Ref:
SSD-82709458

RE: SUBMISSION TO SSD-82709458, Residential development with infill affordable housing
Address: 19-25 Balfour Street, Lindfield

Ku-ring-gai Council's objection to SSD- 82709458, 19-25 Balfour Street, Lindfield

LEVEL 2 FLOOR PLAN
1 : 150

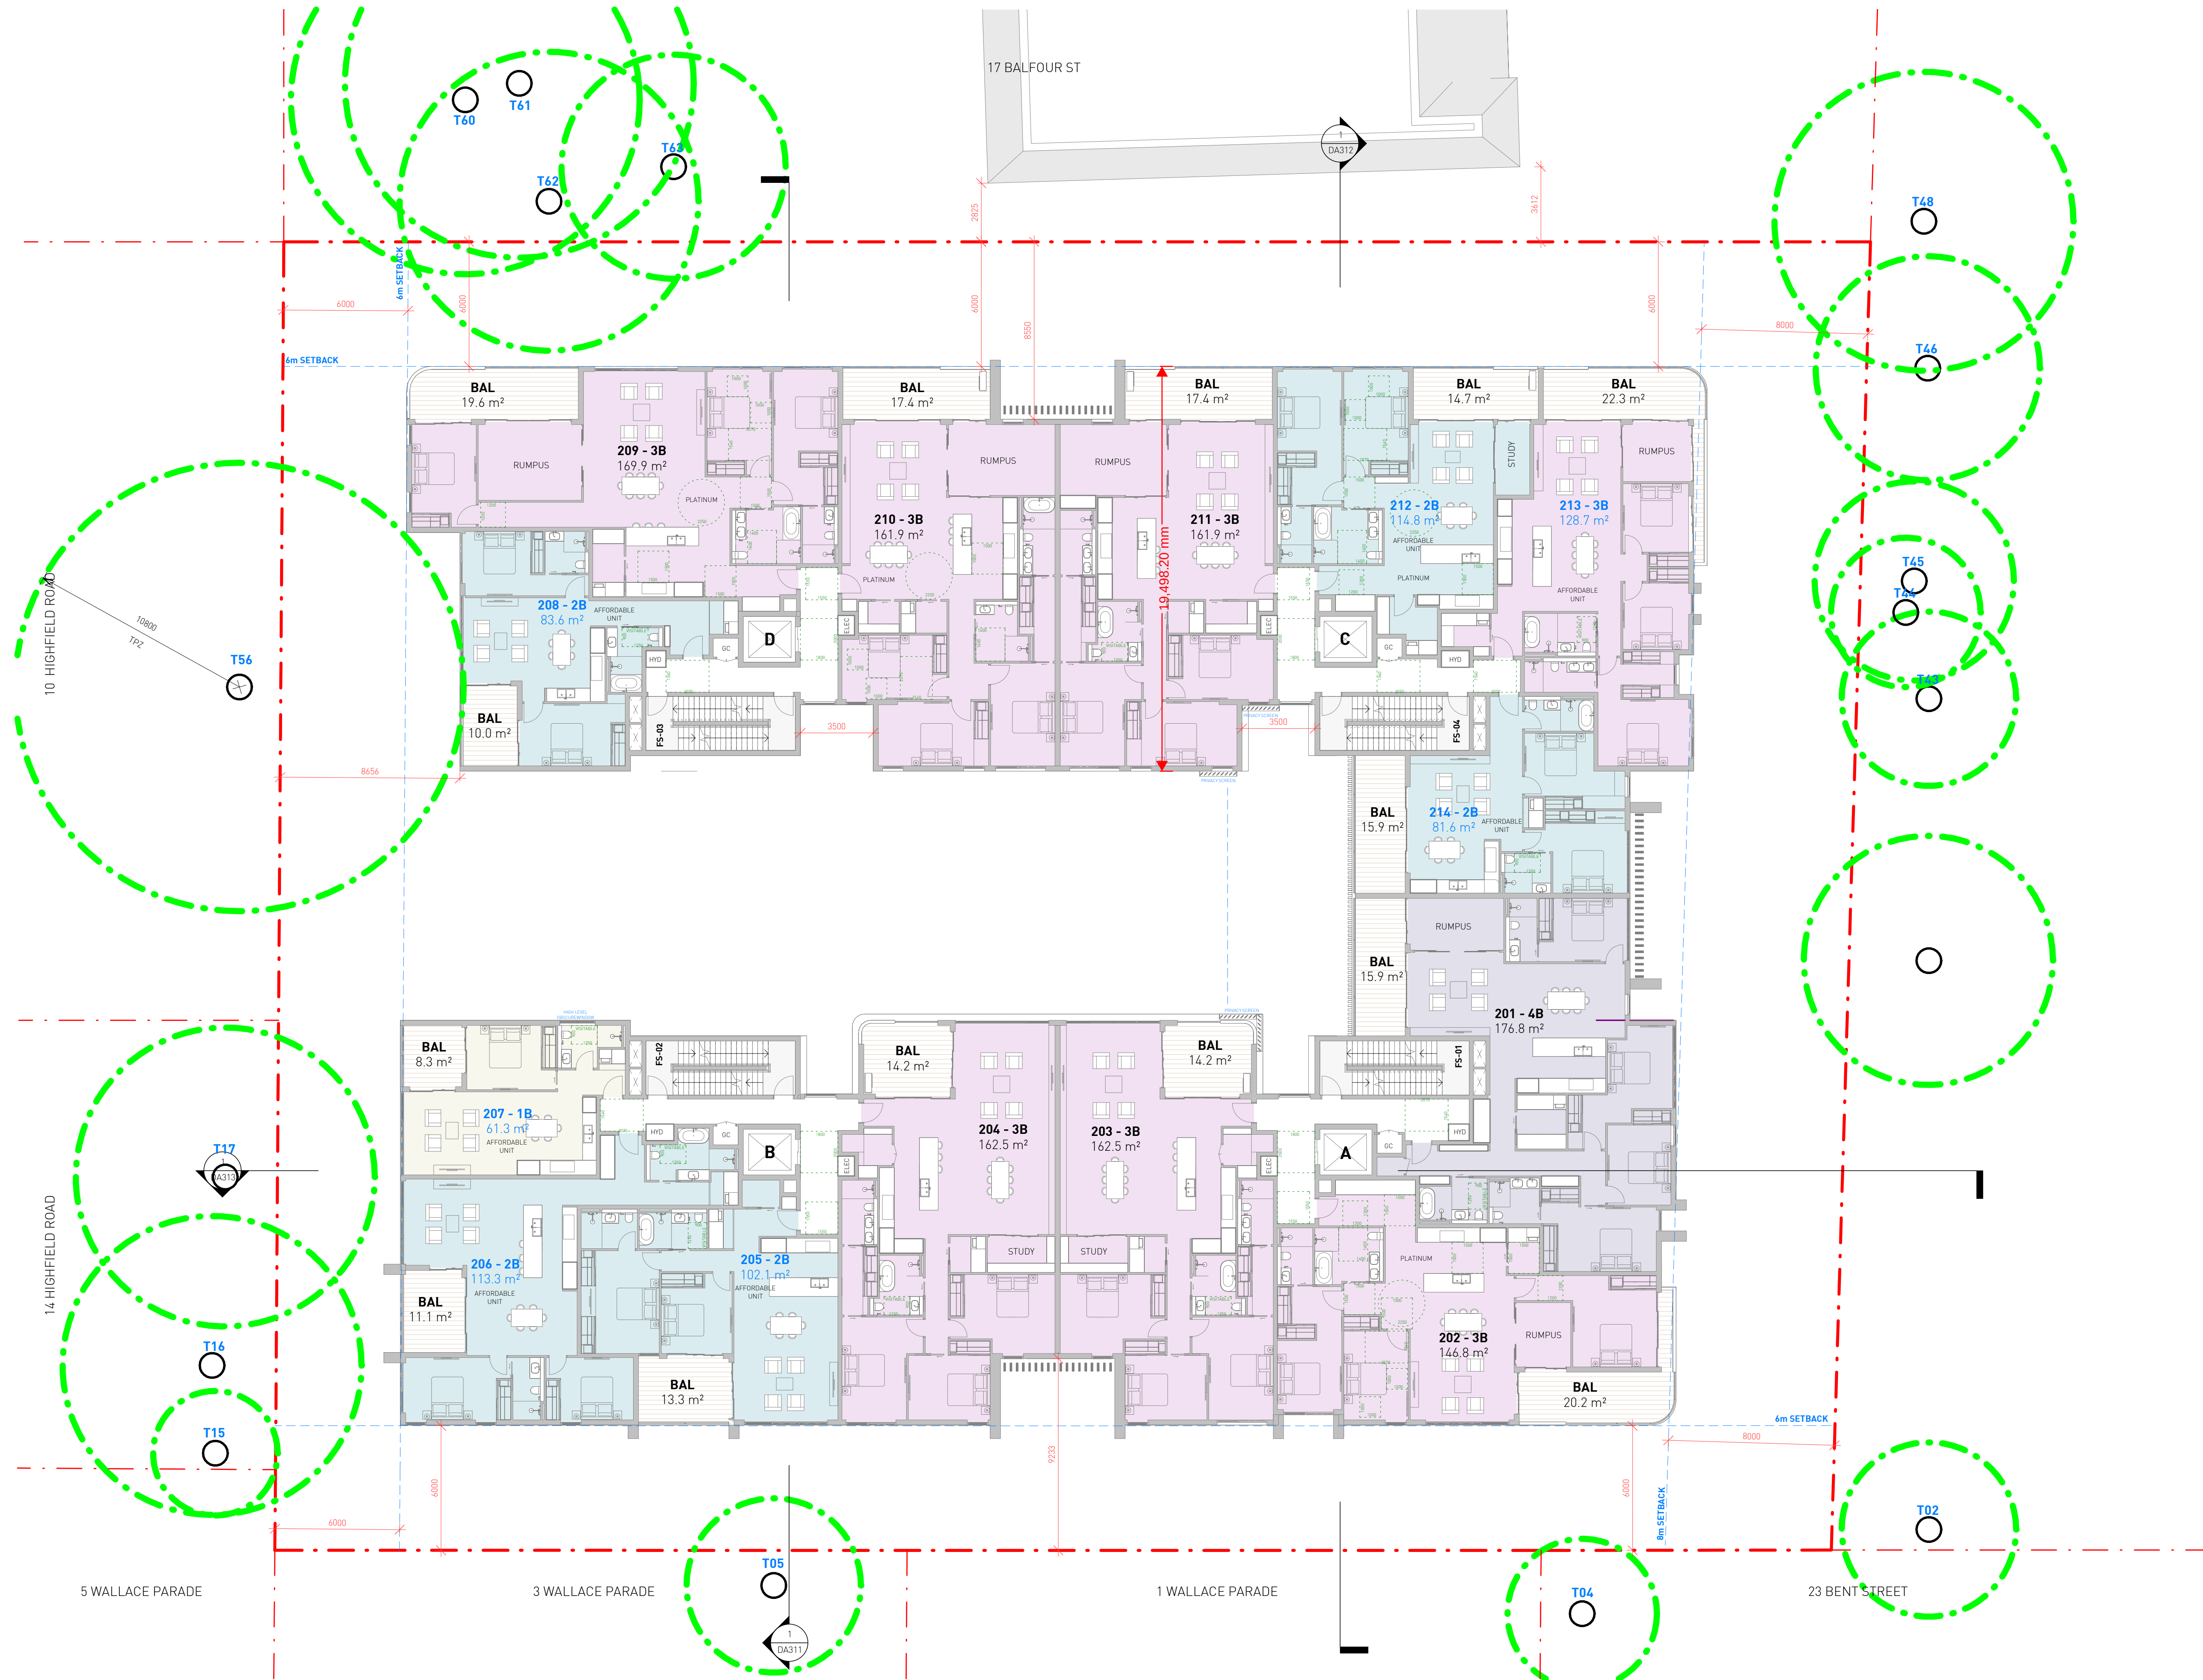
On levels 1-3, the balconies of units 101 and 103, 201 and 203, and 301 and 303 are offset very small distance (its not marked on the plan, but is estimated at approximately 4-5m, when balconies are supposed to be offset 12m.

4
DA400
GFA- LEVEL 1 - 3
1 : 400

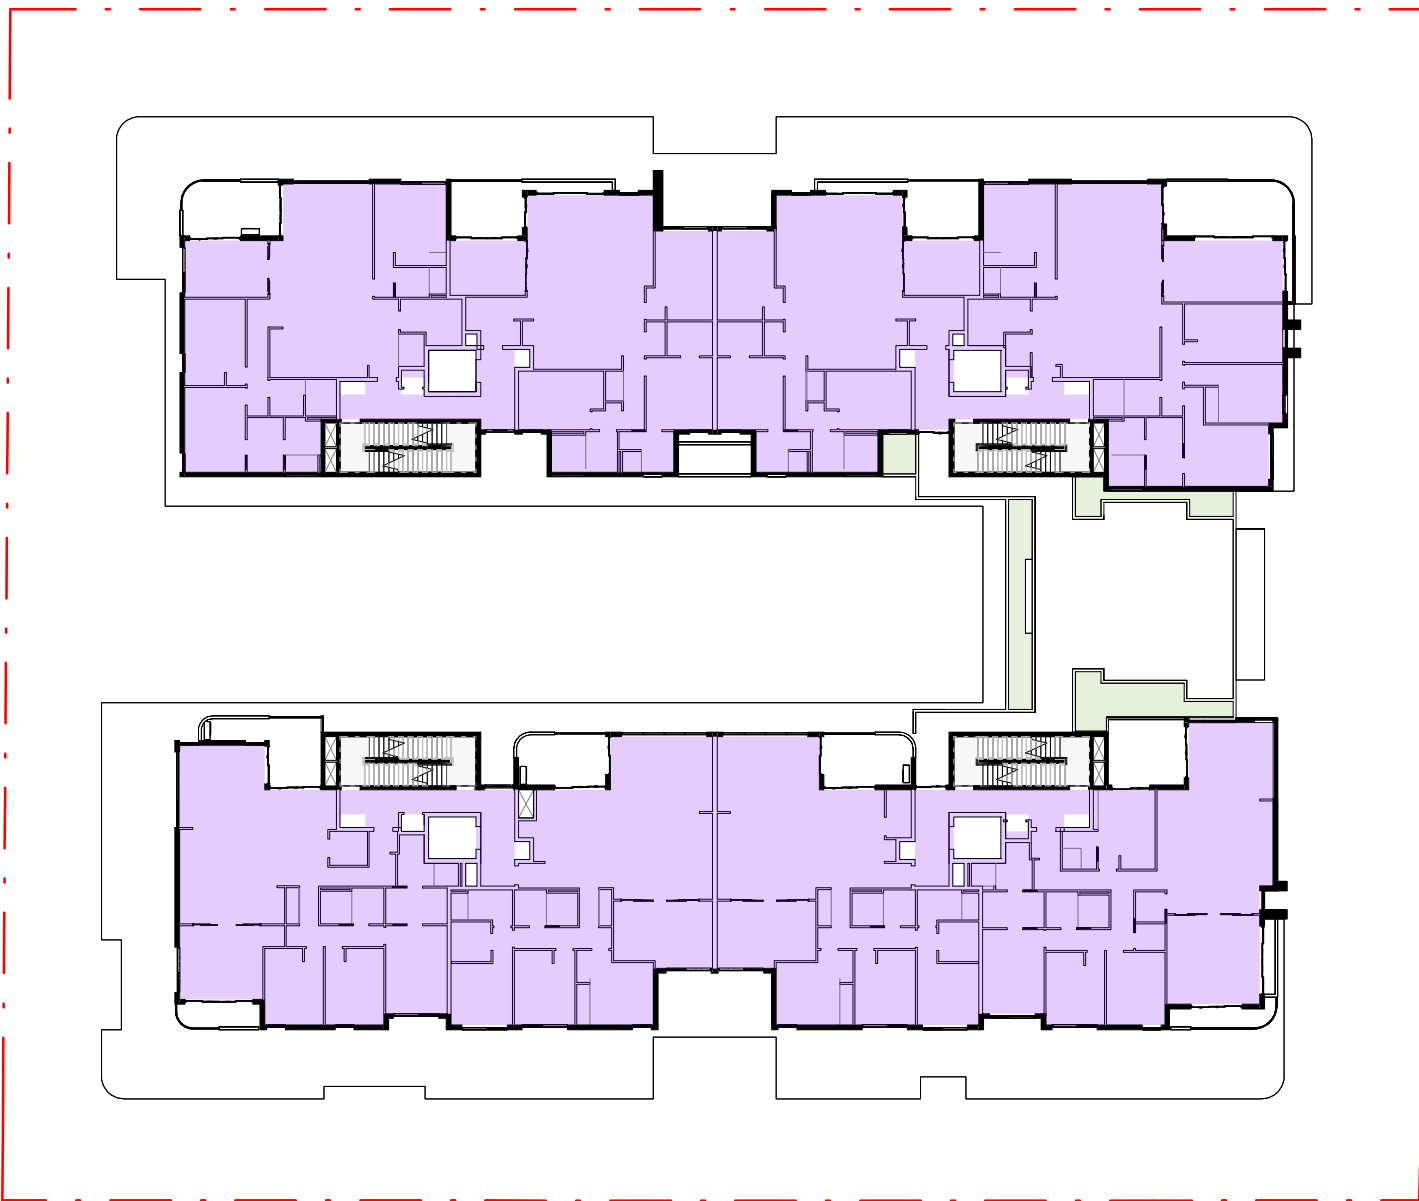
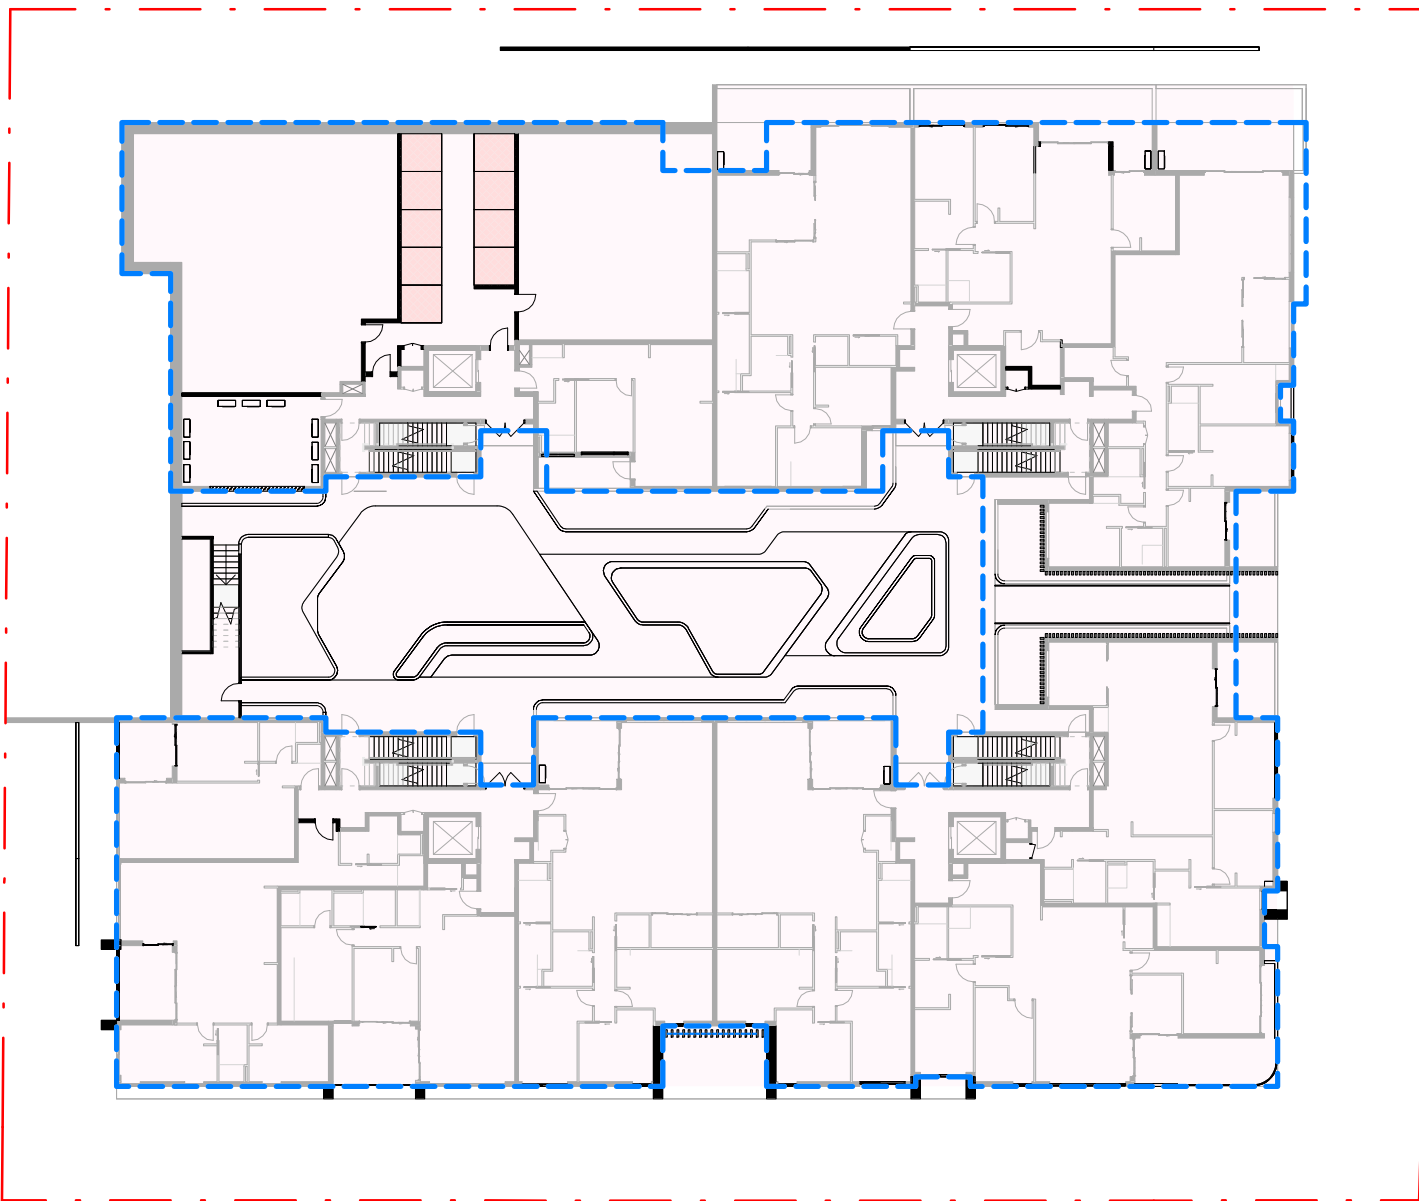
- Part of the living room for G10-3B has been excluded from the GFA calculation.
- It is noted that the GFA overlay appears to not be correctly overlayed in parts.

- Ensure voids match the GFA layer, small void in unit 901-4B is not evident on the floor plan.
